**REQUEST**

Approximately 23.42 acres located along the east side of South Tryon Street and west side of Steele Creek Road, north of Hamilton Road.

The petition proposes to develop a vacant, wooded property in the Steele Creek community with up to 187 multi-family attached dwellings along with accessory uses permitted in the N2-A(CD) zoning district.

DRAWING NO.: **RZ-01**

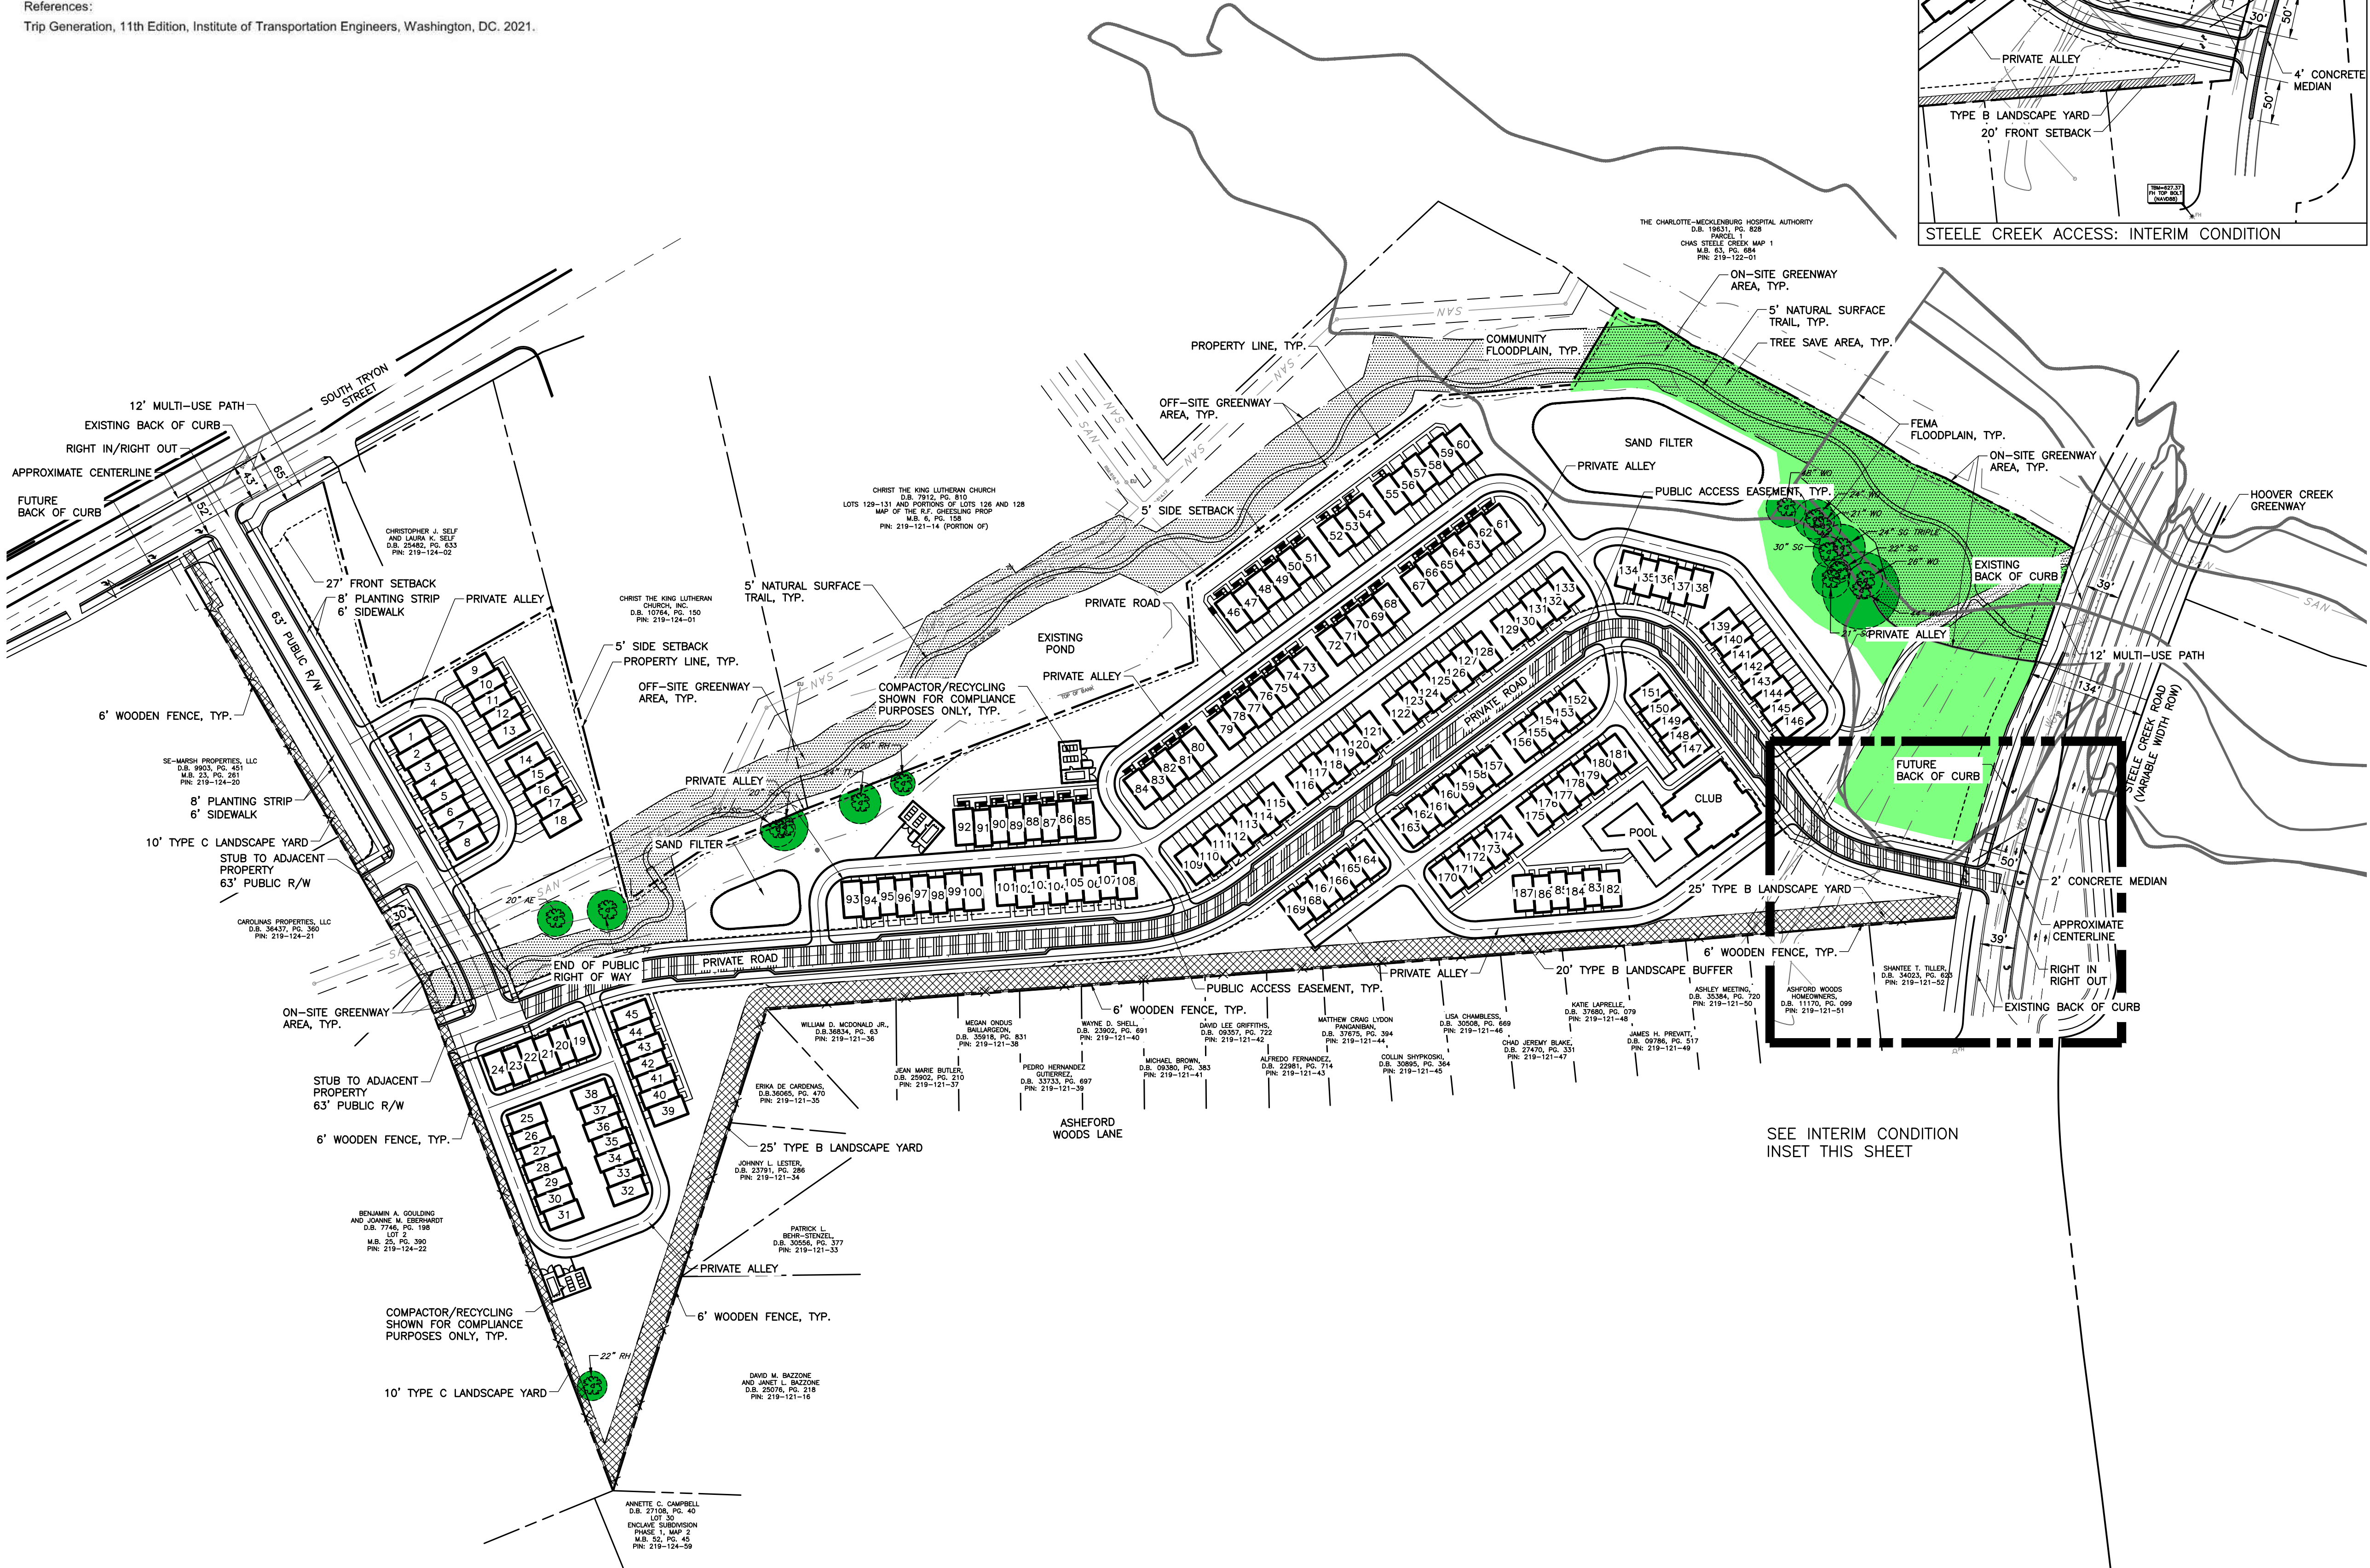
- ~~1. Provide a tree survey showing all city trees 8" DBH or greater and all planted city trees, all existing heritage trees on site, and any existing areas of the site used for credit toward meeting previously approved tree save or green area requirements. **Addressed**~~
- ~~2. Revise site plan to show that tree save areas are contiguous and a minimum of 30' wide. **Addressed**~~

- ~~3. Revise site plan to show interim condition on Steele Creek Road and screen in the final condition to be installed by NCDOT as part of the Steele Creek Widening Project. Callout concrete median on Steele Creek Road on the inset. Label and dimension the median length. Median should be shown to extend to 50' past radius returns at the new street connection. **Addressed**~~
